DECISION DELEGATED TO HEAD OF PLANNING

Application No: H11-0784-23 **Applicant:** Mrs F White-Andrew

Proposal: Use of land for dog walking including proposed fencing

Location: Chase Farm 4 Vicarage Lane Long Sutton

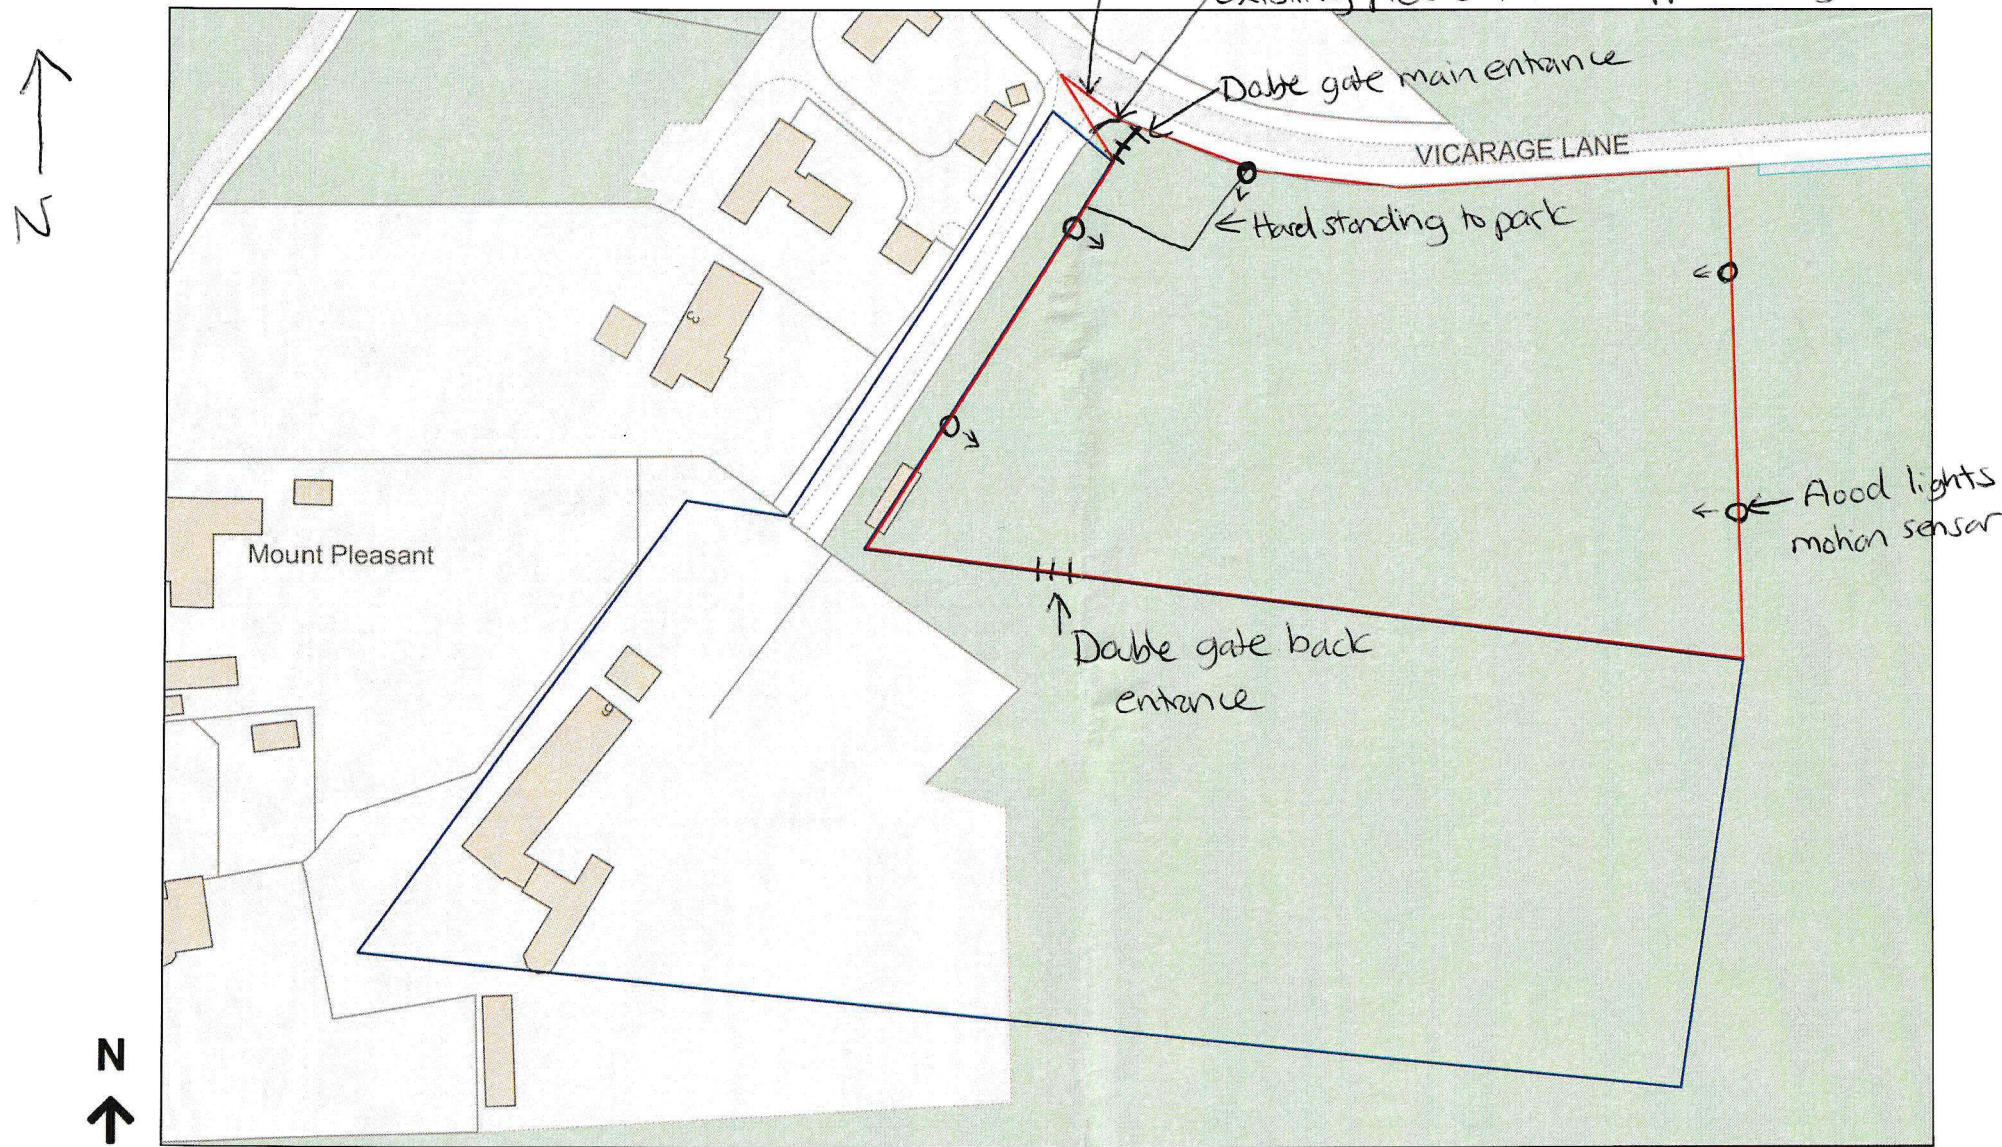
The submitted application form states that the size of the proposal site is 1.12 hectares. However, when the red line boundary was measured from the submitted plans, the area covered measured 0.91 hectares.

The applicant measured the site from Google Maps which led to an inaccurate area measurement. They have confirmed in an email dated 11 January 2024 that if our measurement is more accurate, then to proceed with a proposed area size of 0.91 hectares.
